CITY OF ALBUQUERQUE

October 29, 2020

Re: Sandia Lab FCU
1100 Rio Grande Blvd NW
Traffic Circulation Layout
Engineer's XX-XX-XX (H13-D109)

Based upon the information provided in your submittal received 10-29-2020, the above referenced plan cannot be approved for Building Permit until the following comments are addressed:

ENGINEER'S SEAL	SANDIA LAB FCU RIO GRANDE + 1-40	DRAWN BY RG
	CONSTRUCTION PHASING EXHIBIT	DATE 10-8-2020
	 TIERRA WEST, LLC 5571 MIDWAY PARK PL NE ALBUQUERQUE, NEW MEXICO 87109 (505) 858-3100 www.tierrawestllc.com	DRAWING 2012100-SP
RONALD R. BOHANNAN P.E. #7868		SHEET # E1
		JOB # 2012100

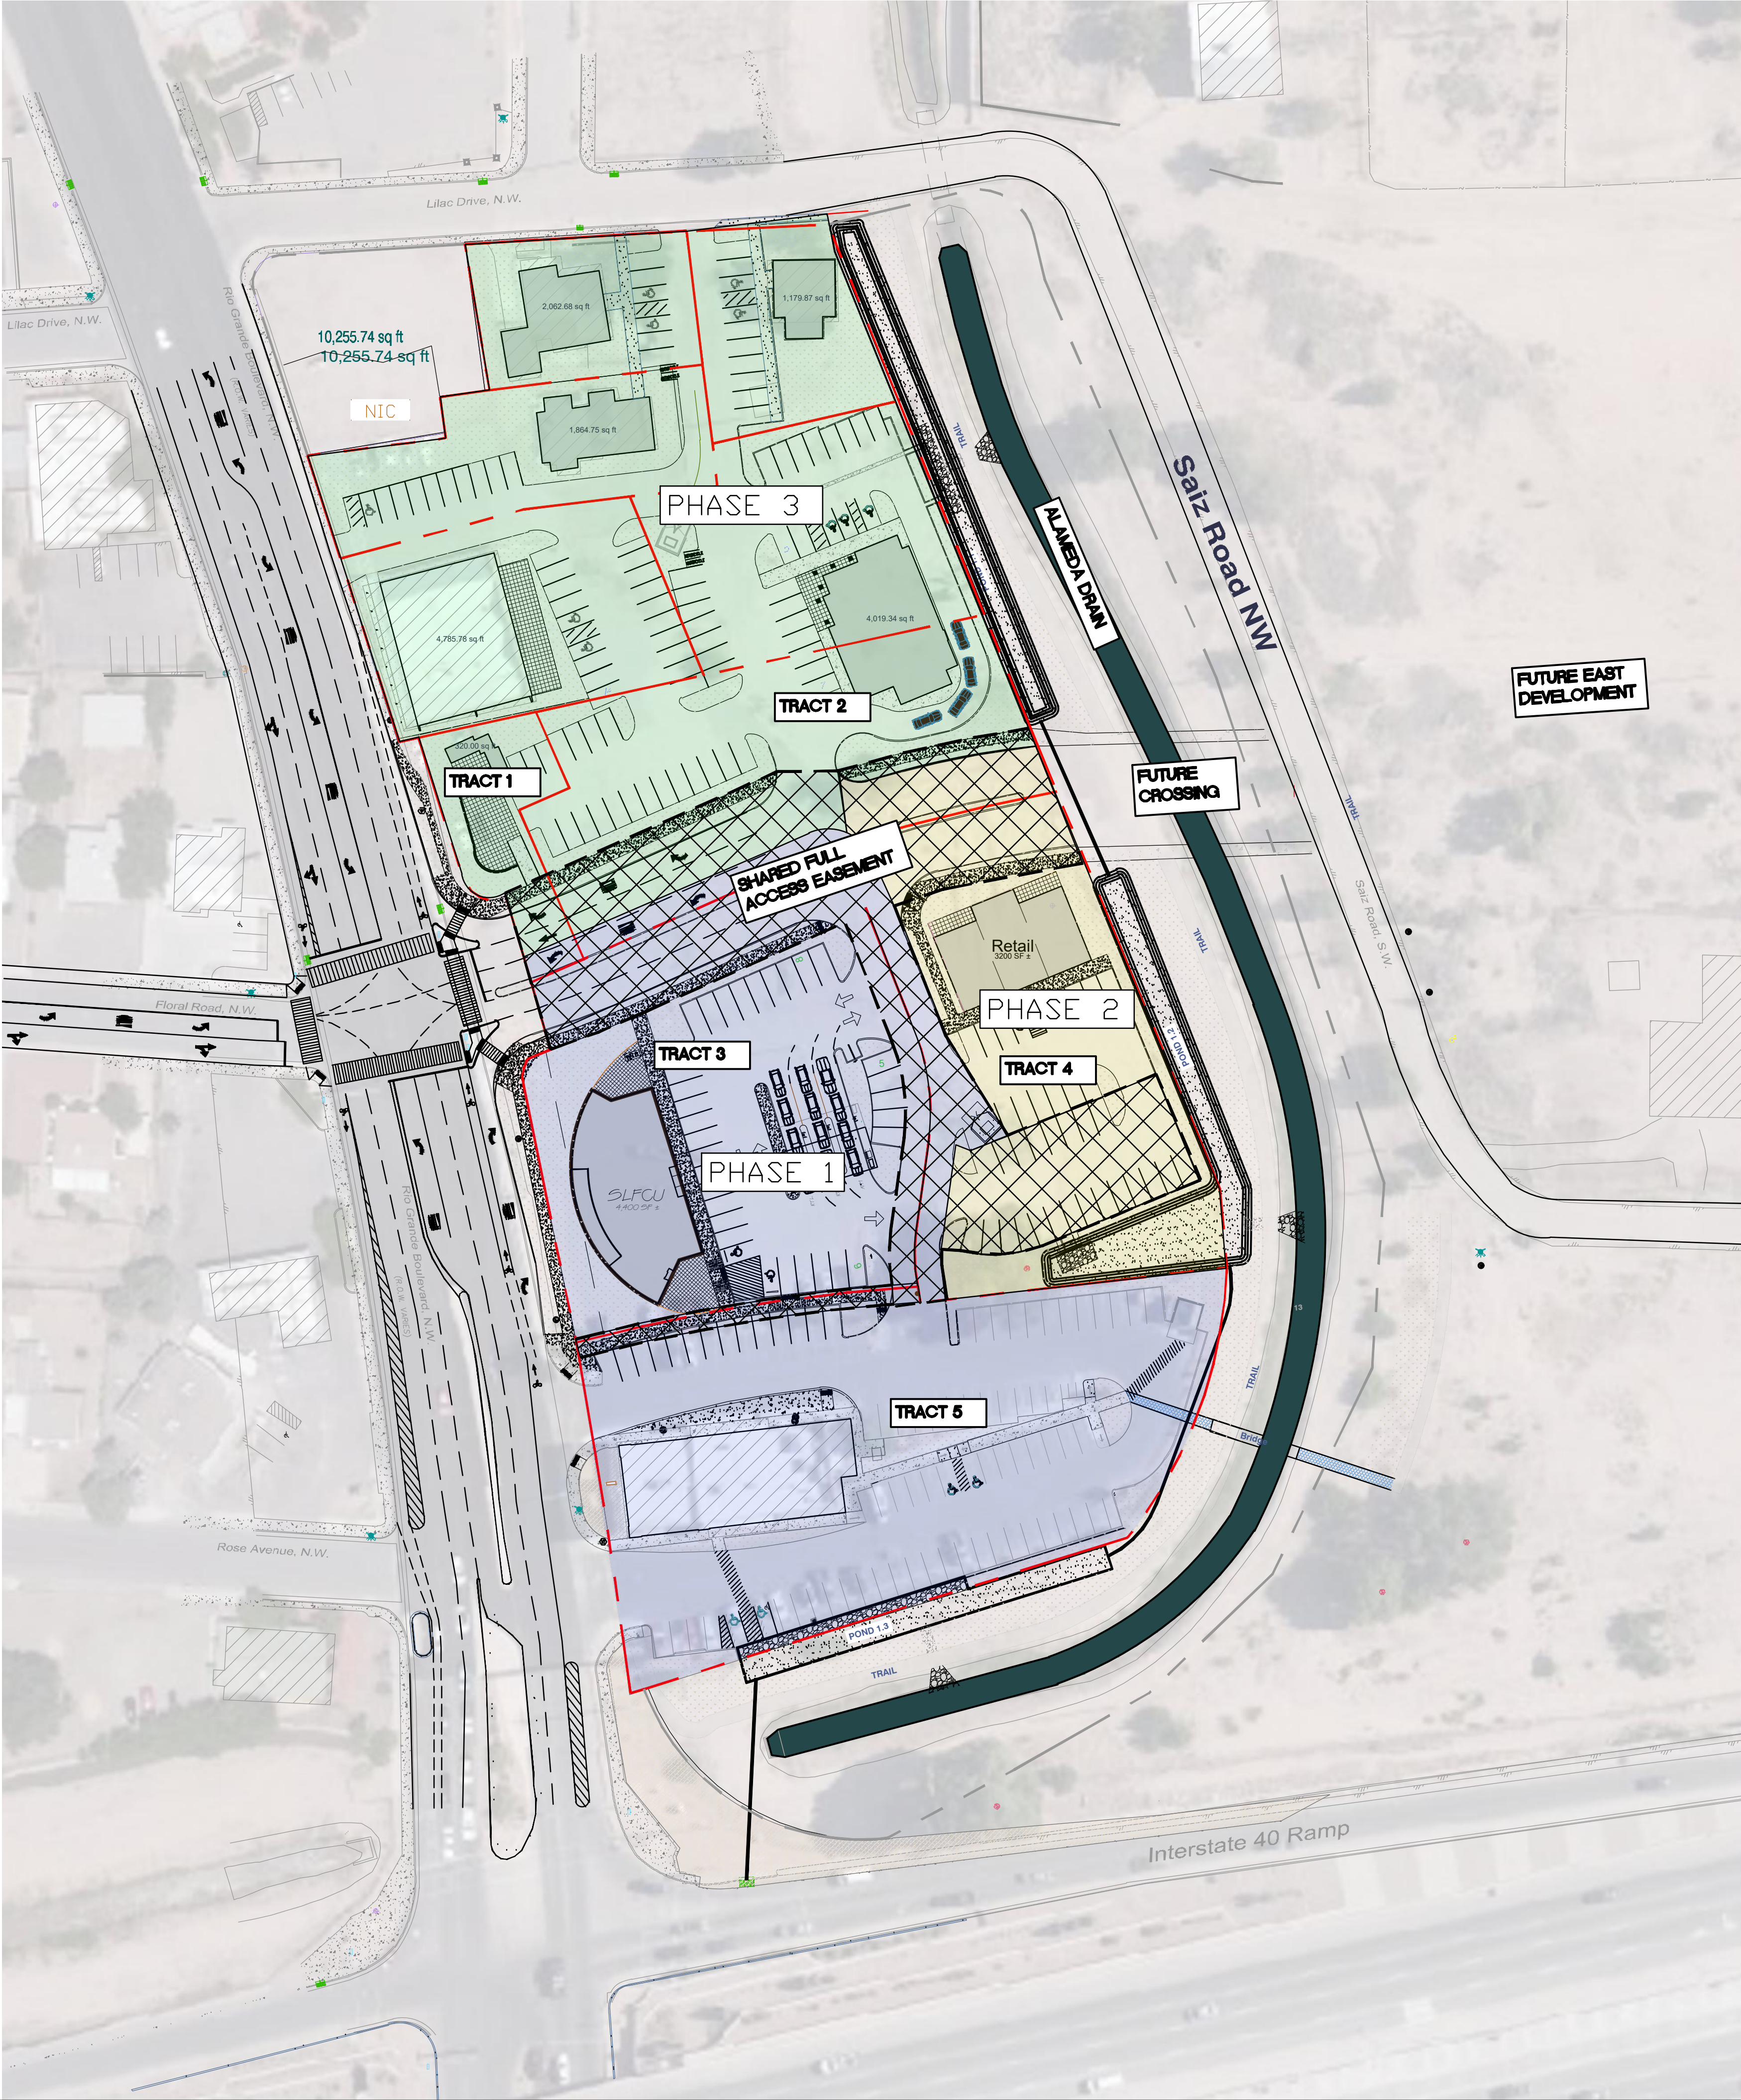
2. Clarify the extents of the current phase. Provide a phasing plan. It appears that you are proposing more infrastructure on different lots. Is there an approved plat to redefine the new lot lines? Please clarify this concern.

ENGINEER'S SEAL RONALD R. BOHANNAN P.E. #7868	SANDIA LAB FCU RIO GRANDE + 1-40	DRAWN BY RG
	SIGHT DISTANCE EXHIBIT	DATE 10-8-2020
	TERRA WEST, LLC 5571 MIDWAY PARK PL NE ALBUQUERQUE, NEW MEXICO 87109 (505) 858-3100 www.tierrowestllc.com	DRAWING 2012100-SP
		SHEET # E2
		JOB # 2012100

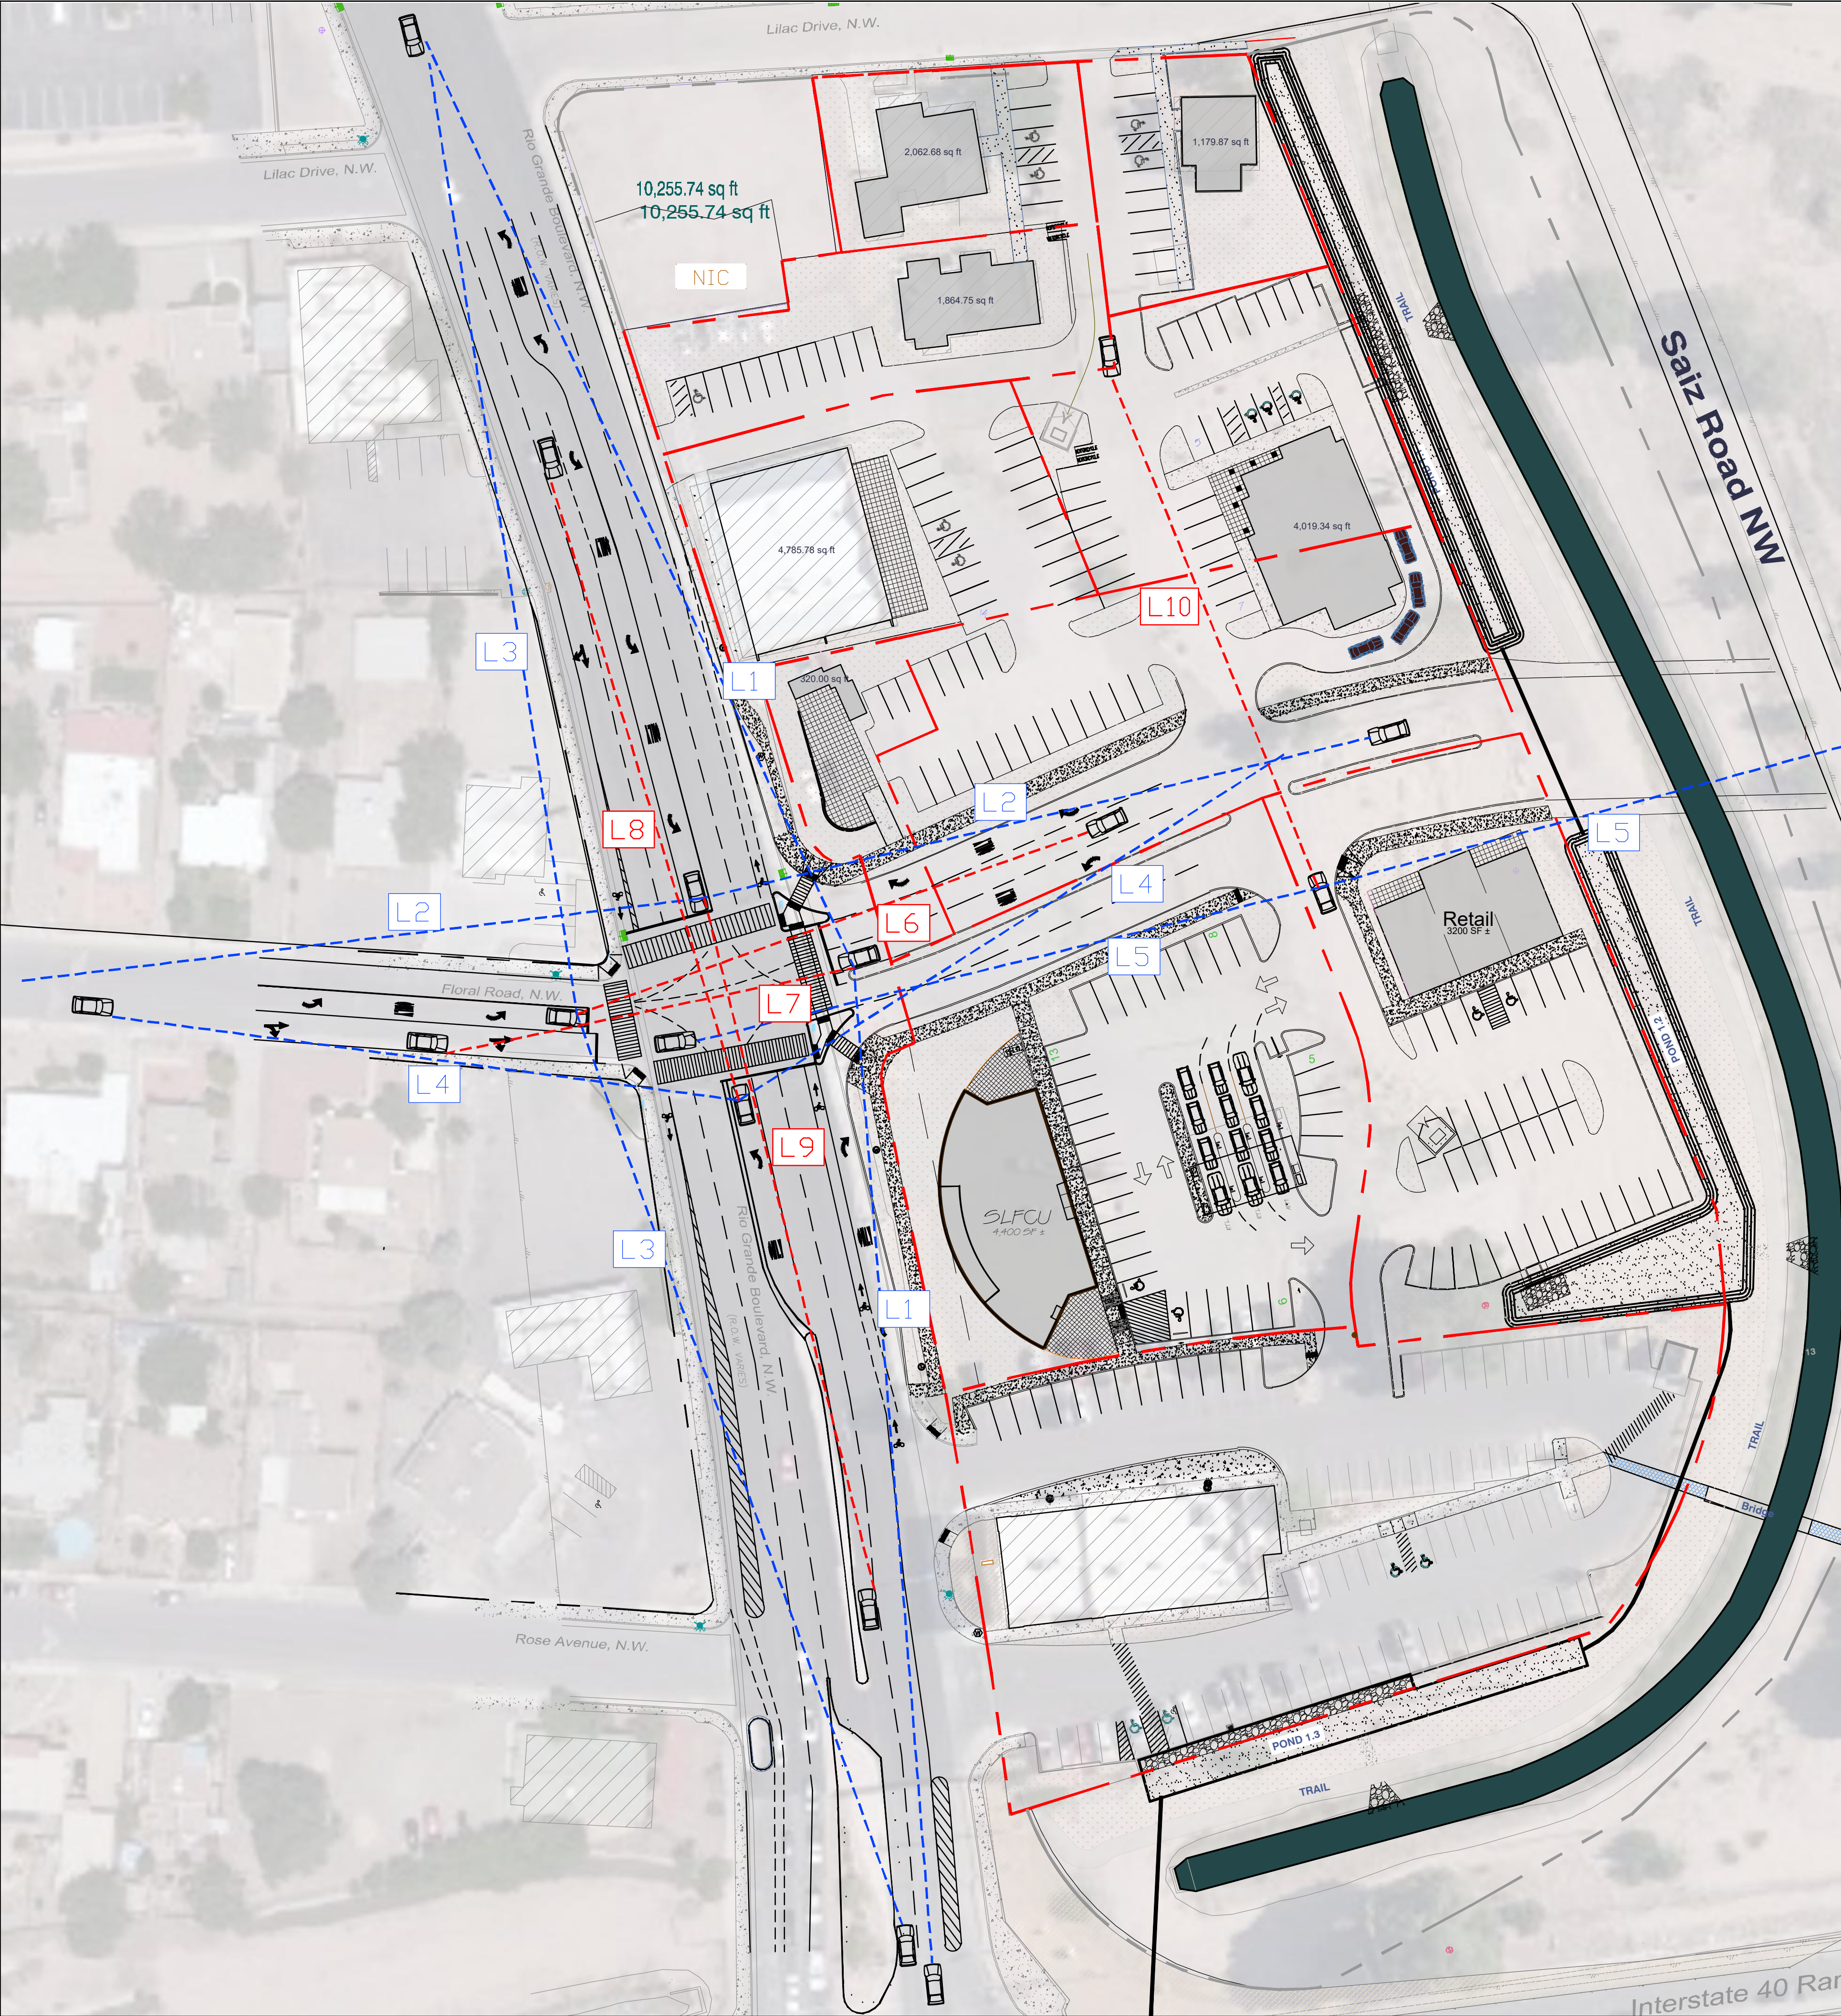
29. Please provide a sight distance exhibit
30. Show the clear sight triangle and add the following note to the plan:
"Landscaping and signage will not interfere with clear sight requirements. Therefore, signs, walls, trees, and shrubbery between 3 and 8 feet tall (as measured from the gutter pan) will not be acceptable in the clear sight triangle."
